Comments for Planning Application 21/01391/HOUSE

Application Number: 21/01391/HOUSE

Address: 7 Kingsingfield Close West Kingsdown KENT TN15 6LP

Proposal: Demolition of existing single storey garage and outbuilding. New single storey rear extension with flat roof and glazed lantern light. New two storey side extension.

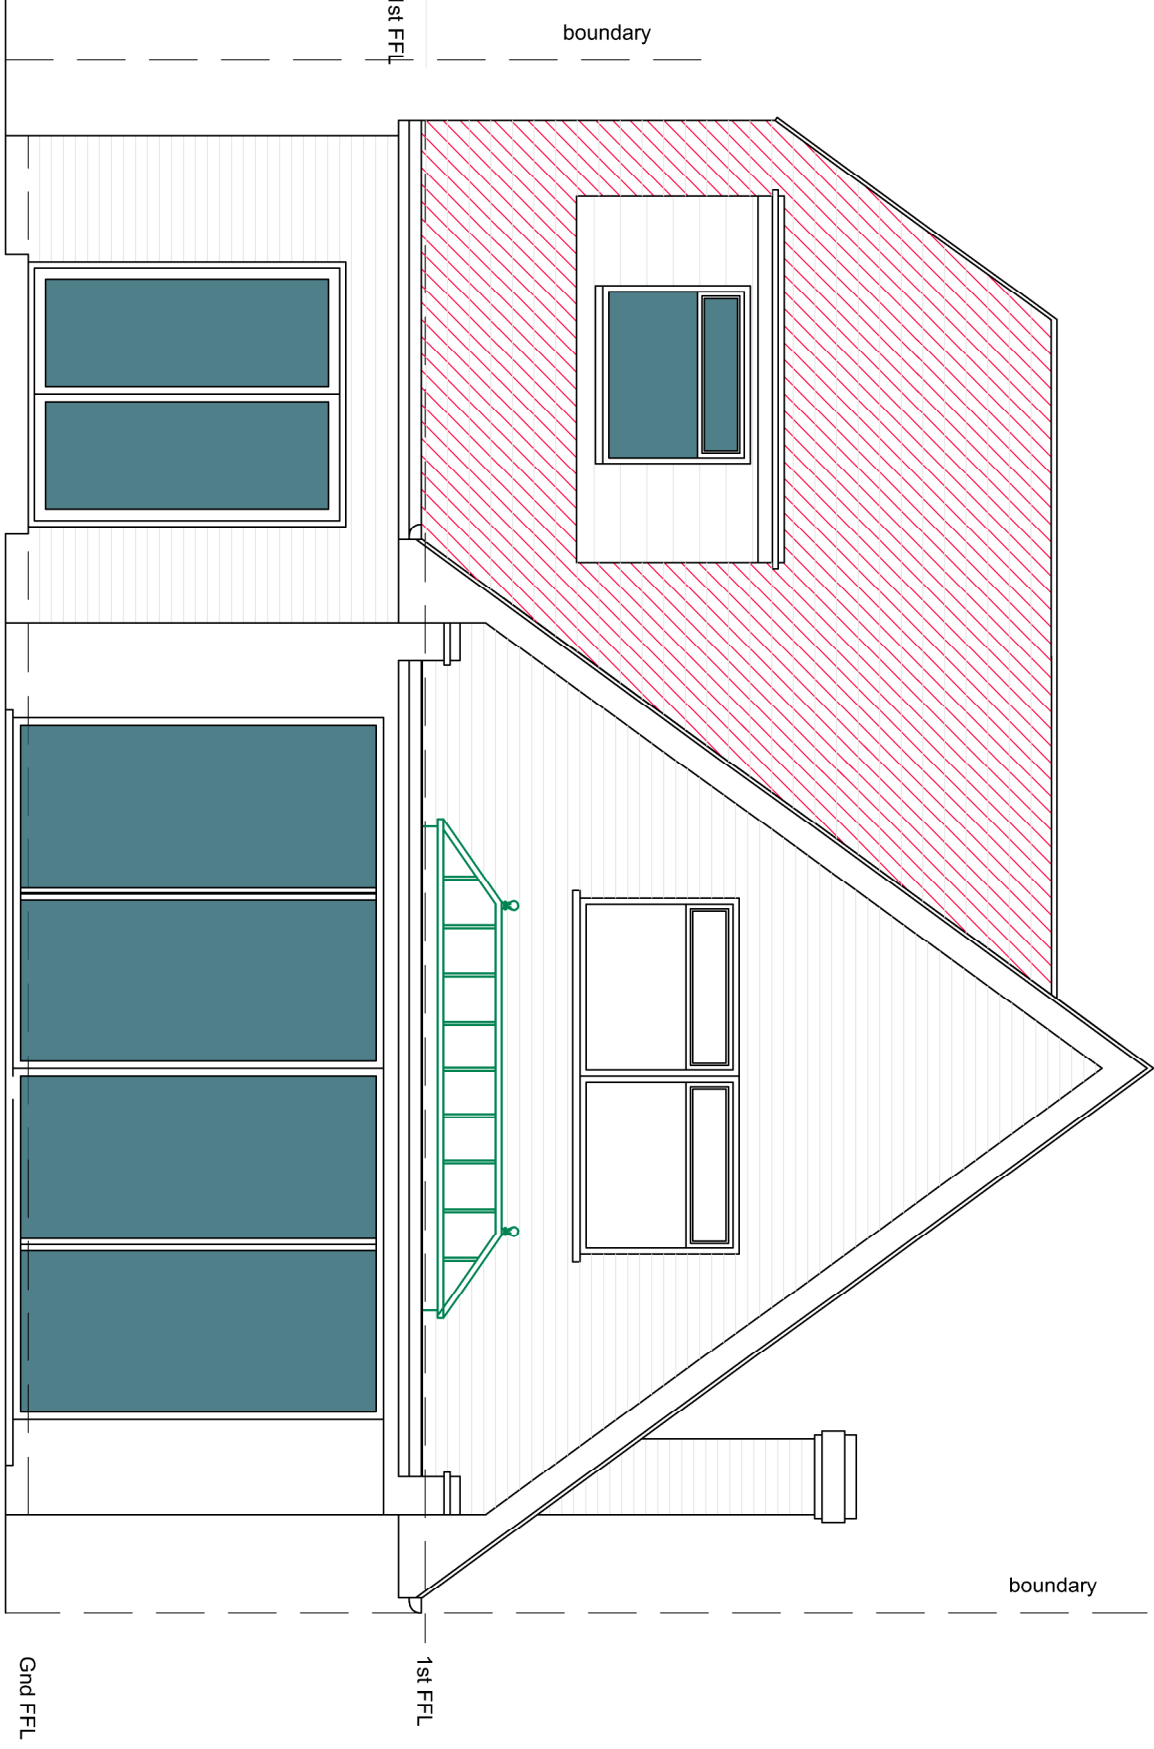
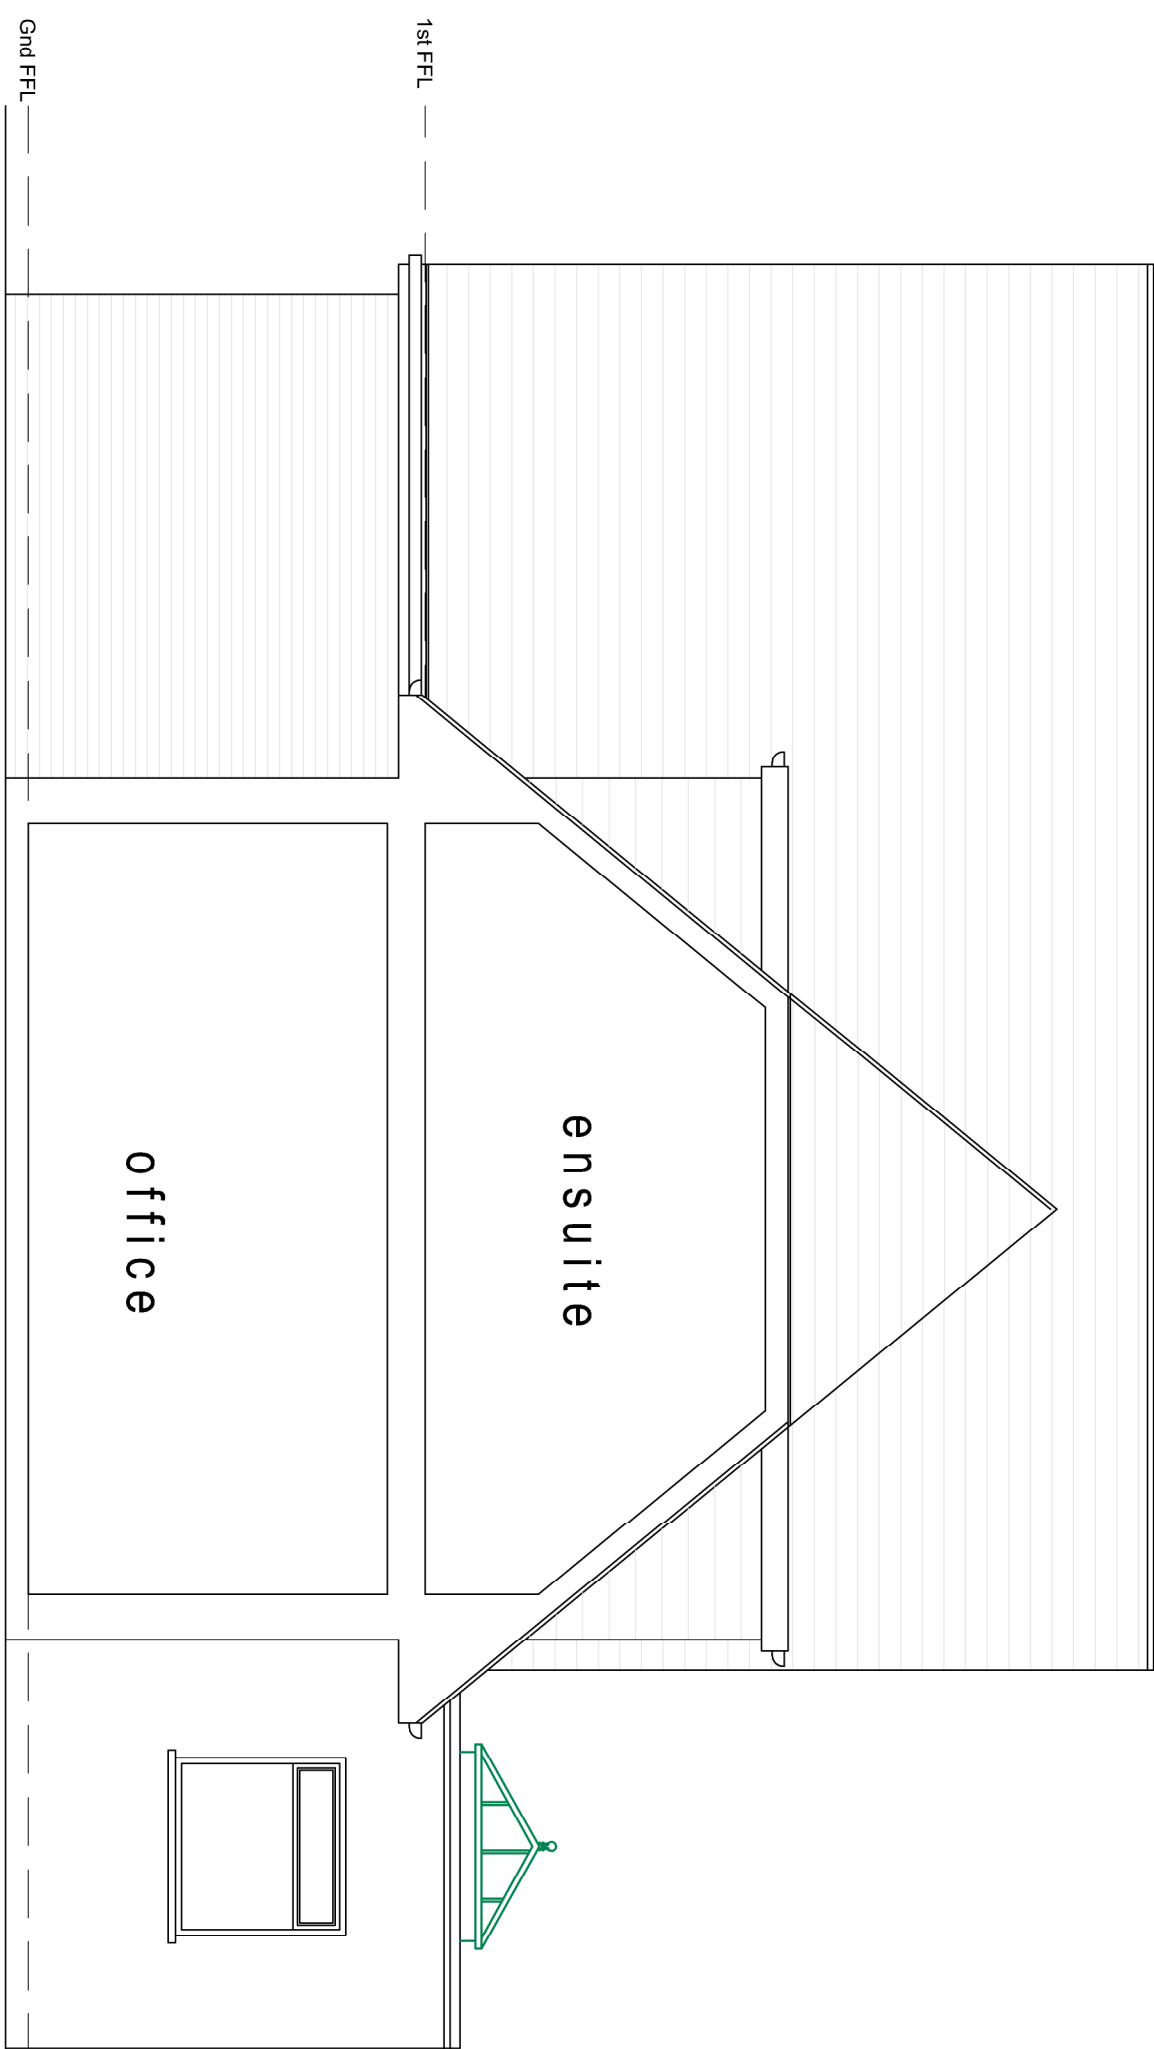
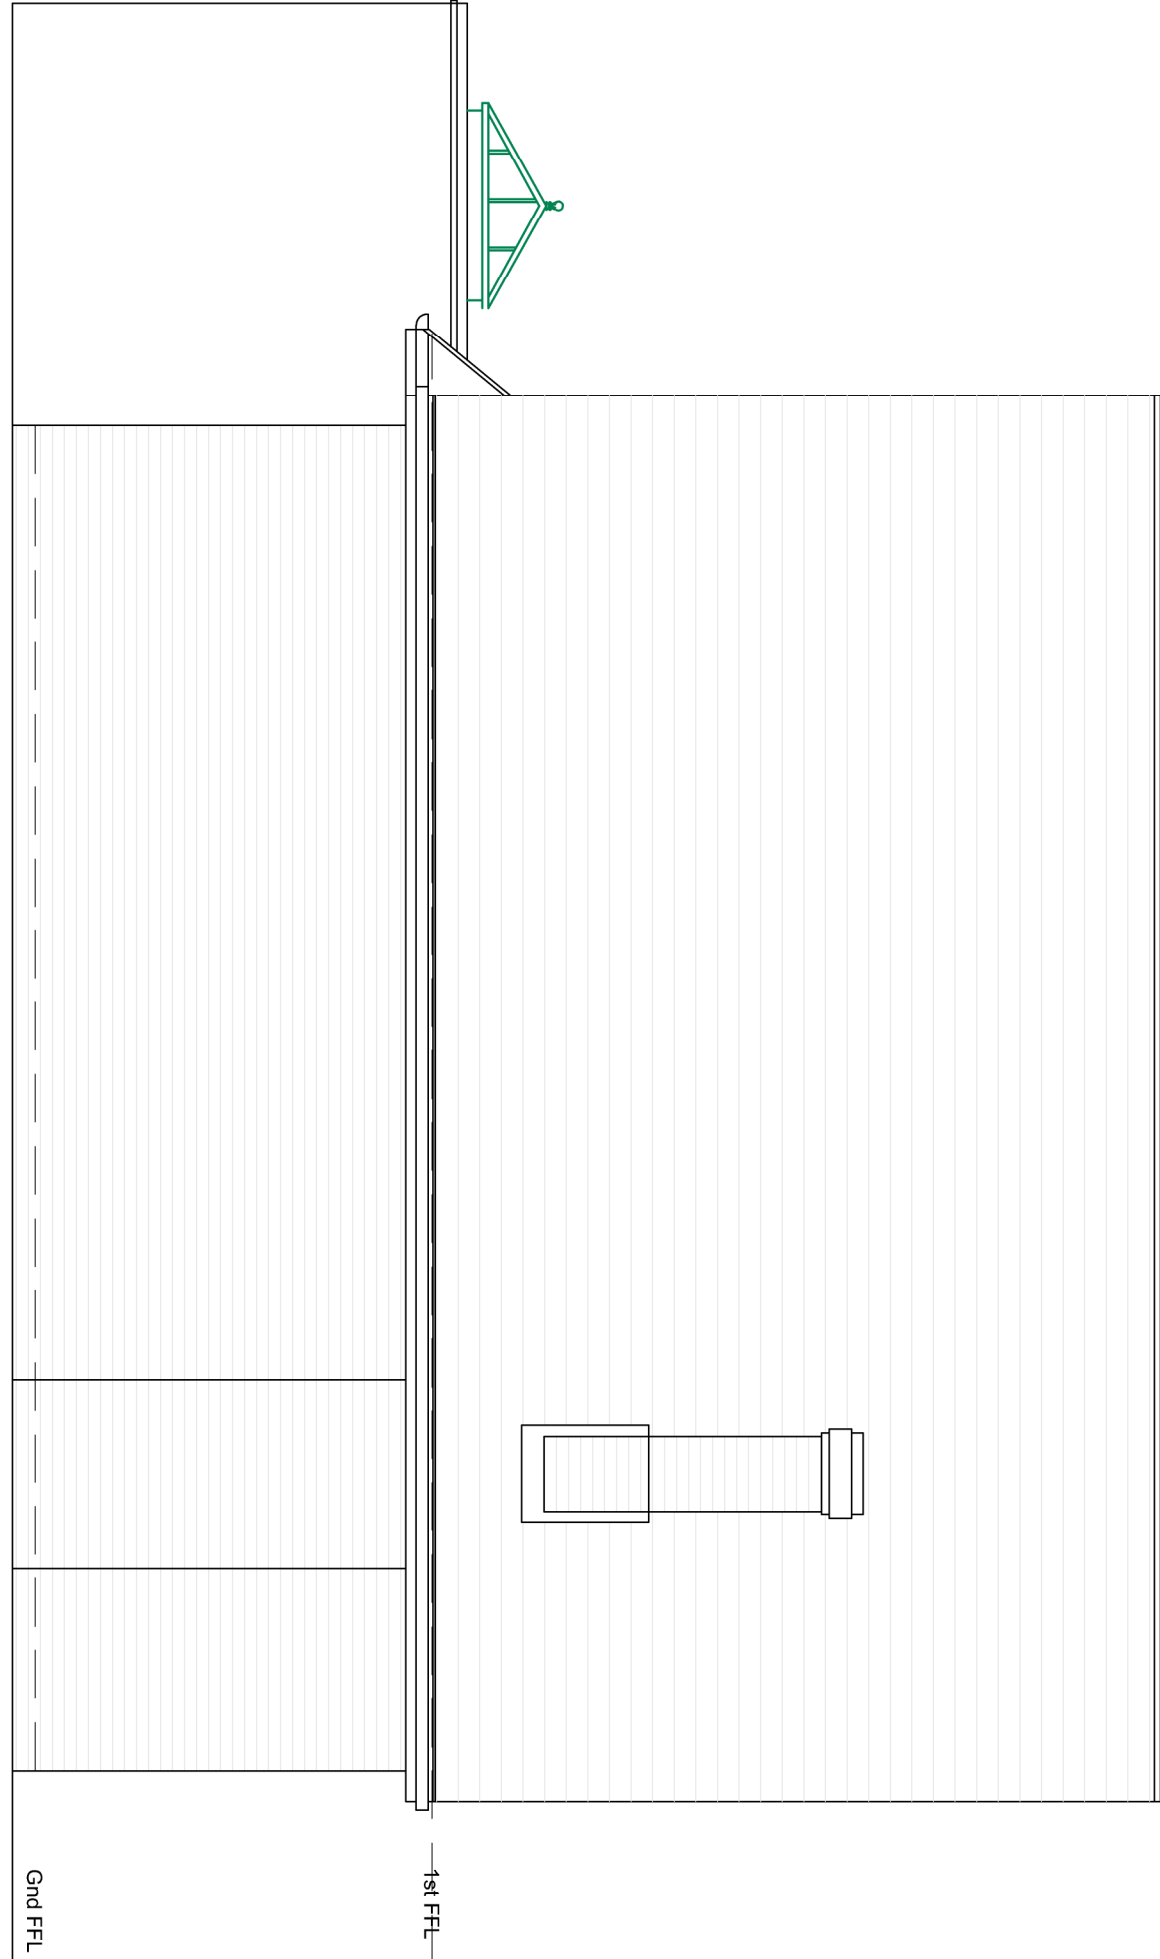
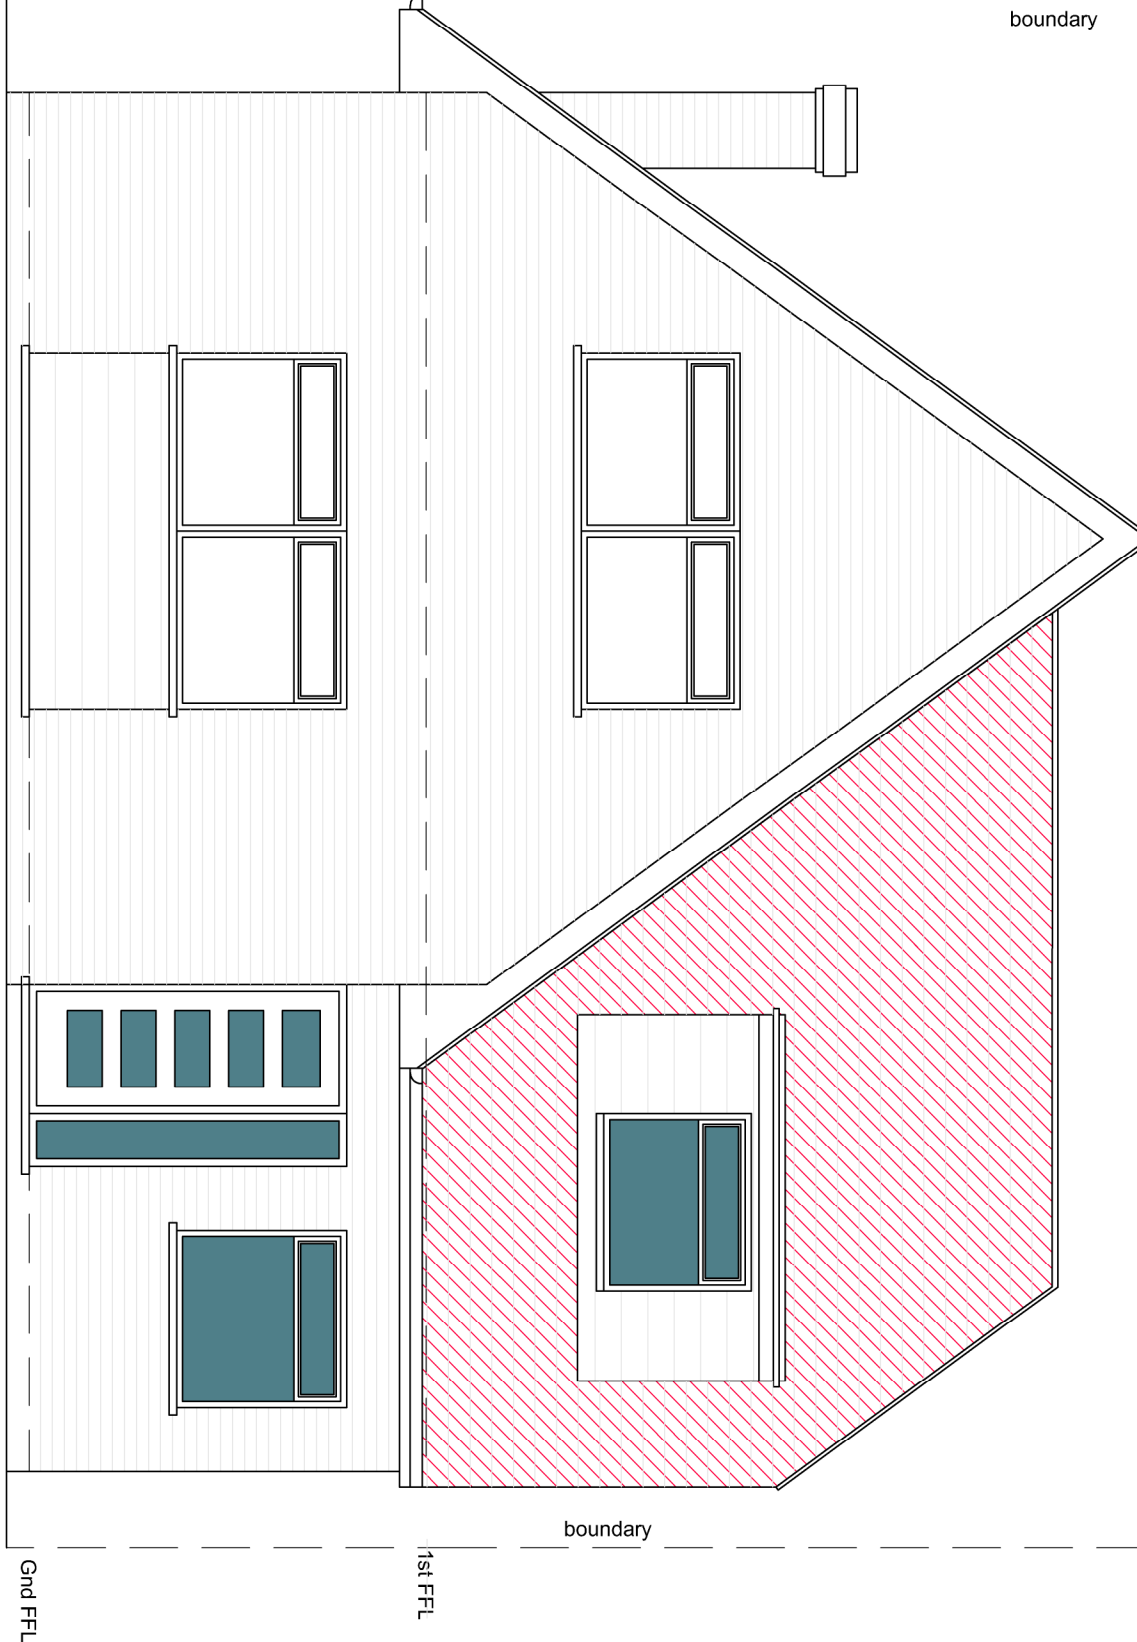
It would not be in keeping with the other 7 identical houses in Kingsingfield Close and would irrevocably change the street scene of the close

The 2 storey extension will overlook our property intruding on our privacy, as they stated they already have a small garden in close proximity to our boundary fence. They already have one first floor window overlooking our property and are now proposing a second one.

The first floor window would impact on our privacy and that of other properties. If permission were granted it would be expected that a condition of a non opening obscured glass window be made.

The two storey extension would give very limited space between numbers 6 and 7 Kingsingfield Close and would block out light and sunlight from the gardens

Parking: This extension would result in there only being one parking space to the front of their property meaning that their second car would have to be parked on the cul-de-sac road causing difficulty for emergency vehicles, refuse collection vehicles and the other residents access and road safety in the close.
